From: [REDACTED]
Sent: 29 September 2021 15:20
To: Planning
Subject: Ref: 3/2021/0898 - 3 Moor Field Whalley BB7 9AS

Planning Application Reference Number: 3/2021/0898

Address of Development: 3 Moorfield, Whalley.

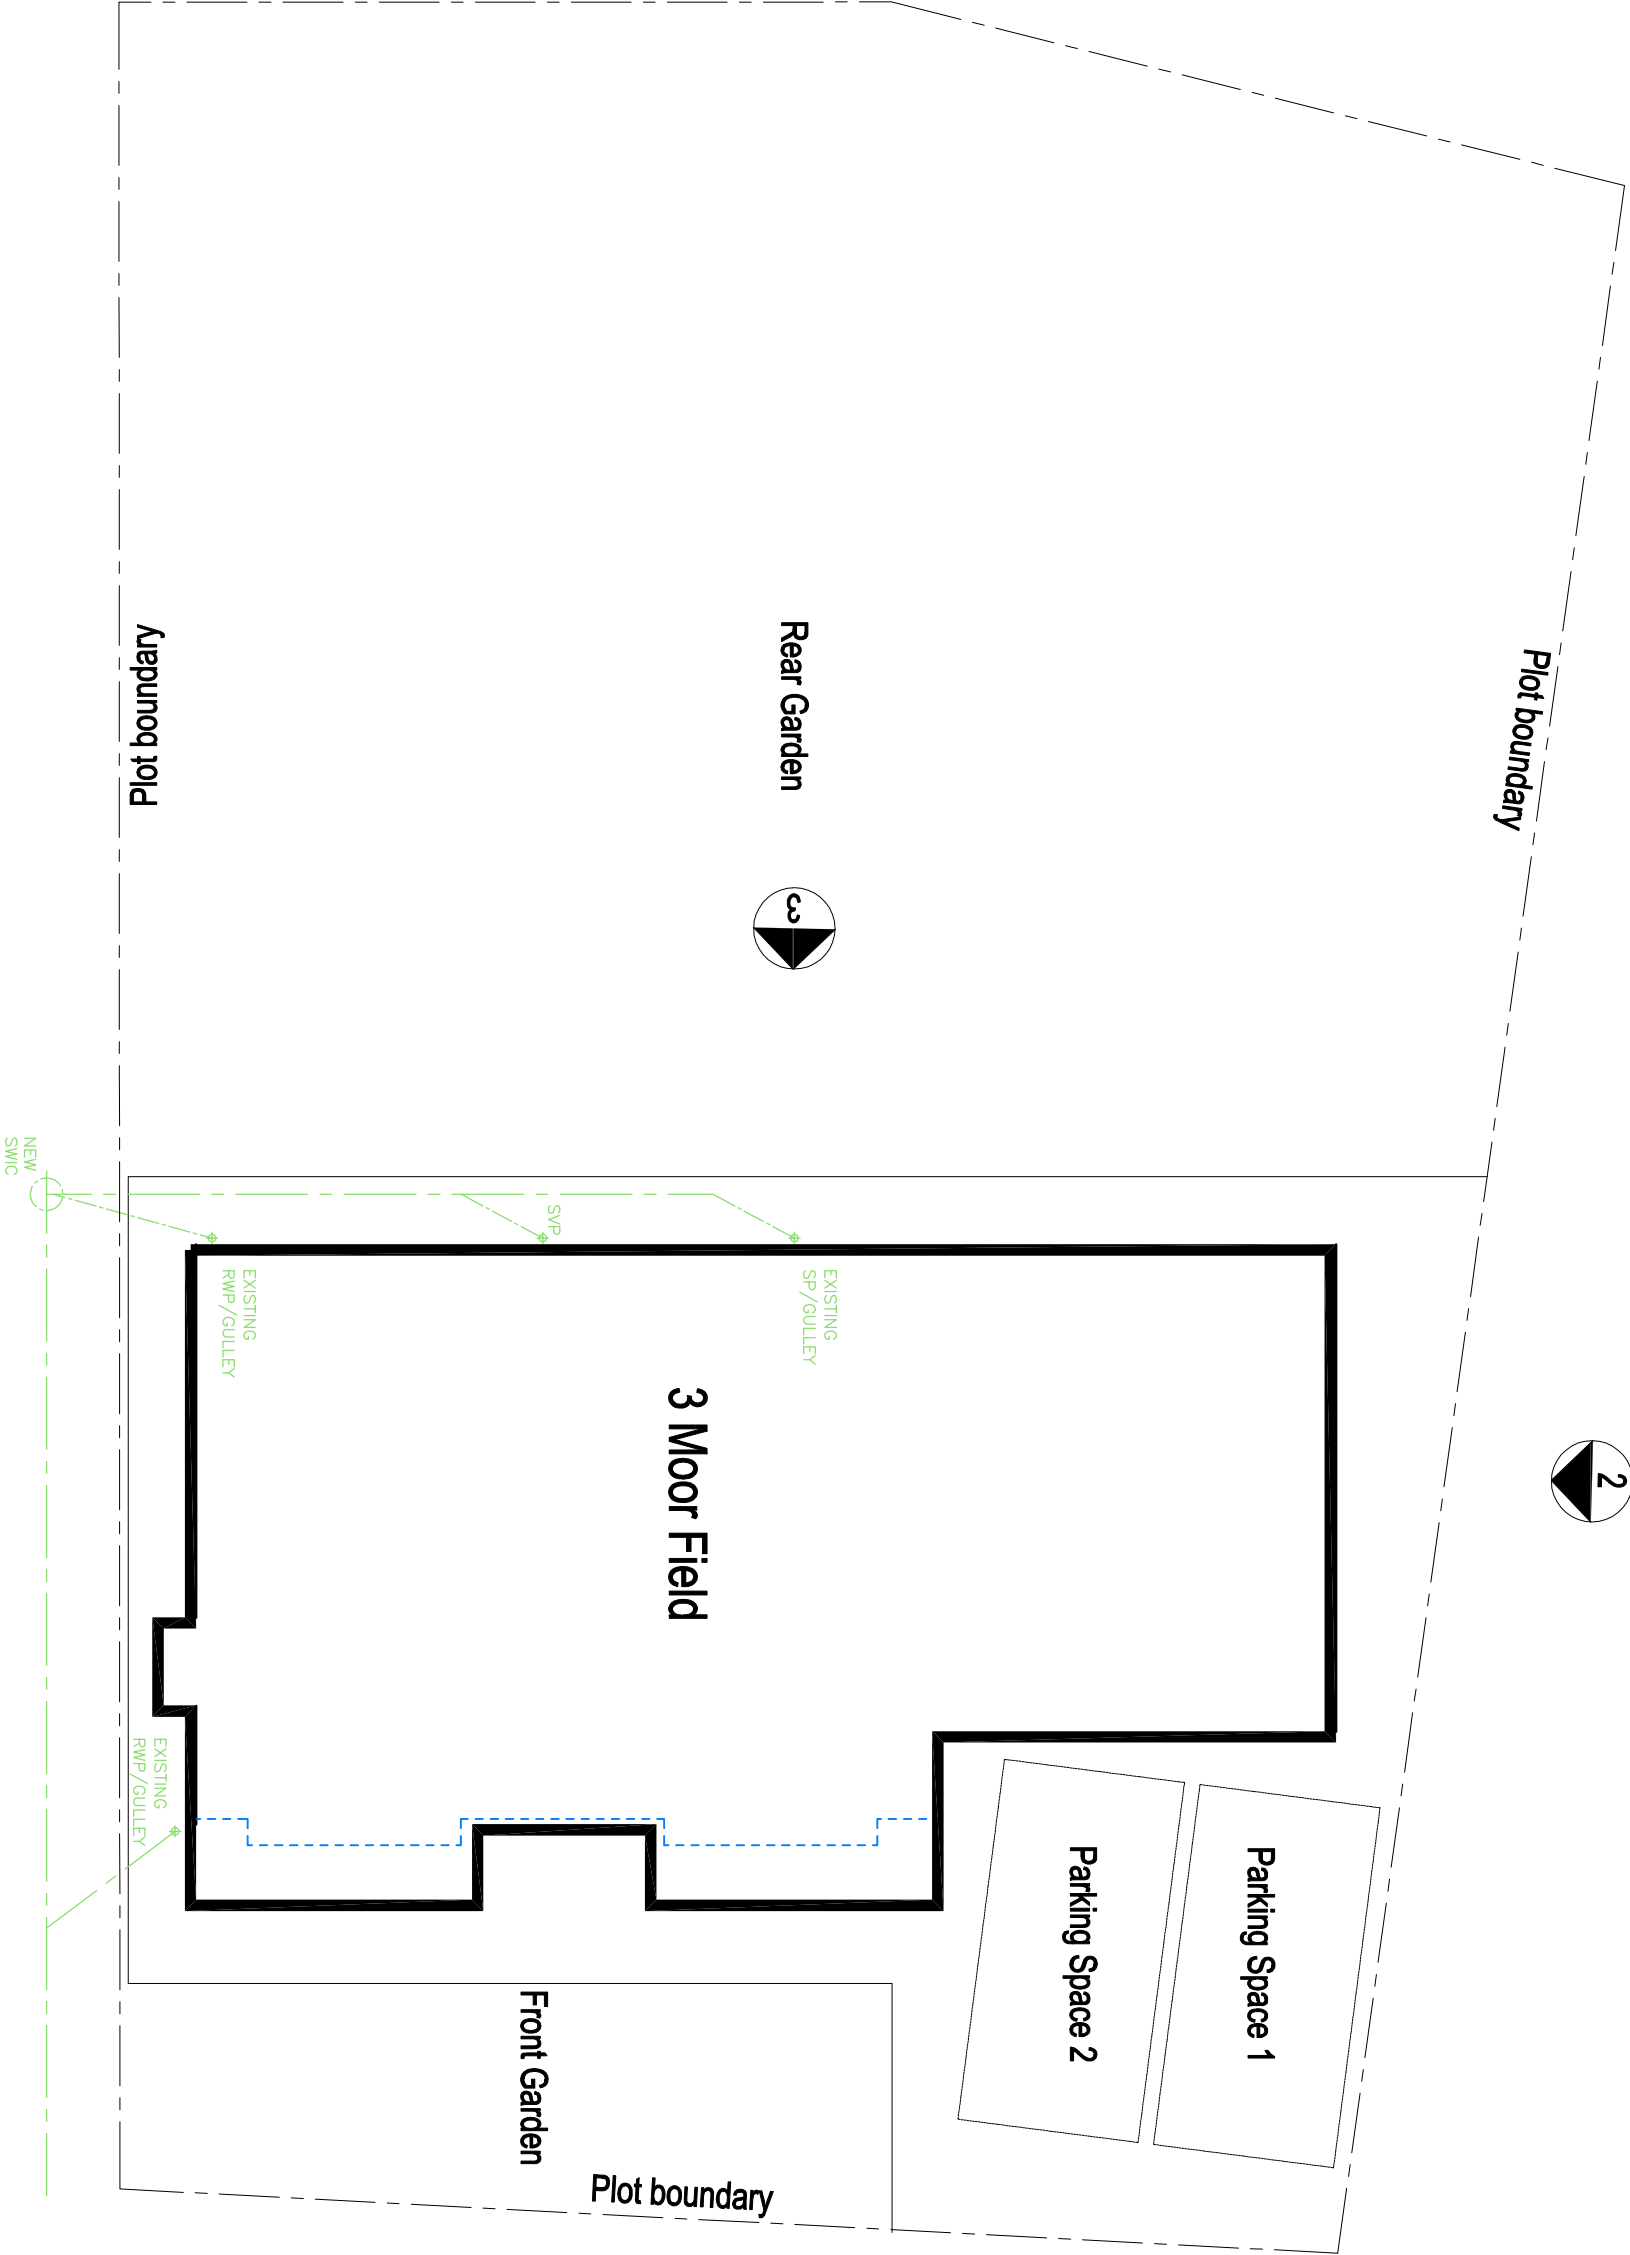
Your Comments: I would like to object to the above planning application on the grounds that the proposed development will extend beyond the building line of the existing houses and be of detriment to the street scene, undermining the urban fabric [REDACTED] There are numerous examples on Moorfield of how to modernise and improve these bungalows without protruding beyond the existing building line or creating new roof ridges. This proposal does both and will be a permanent reminder of bad and inappropriate design which is not in keeping with the existing street scene. The drawings provided are front elevations which do not highlight the issues that I raise. Elevations looking up or down Moorfield from north to south or south to north would present this proposal in the monstrous state that pays complete disregard to its surroundings. The architectural practise responsible should be ashamed of themselves.
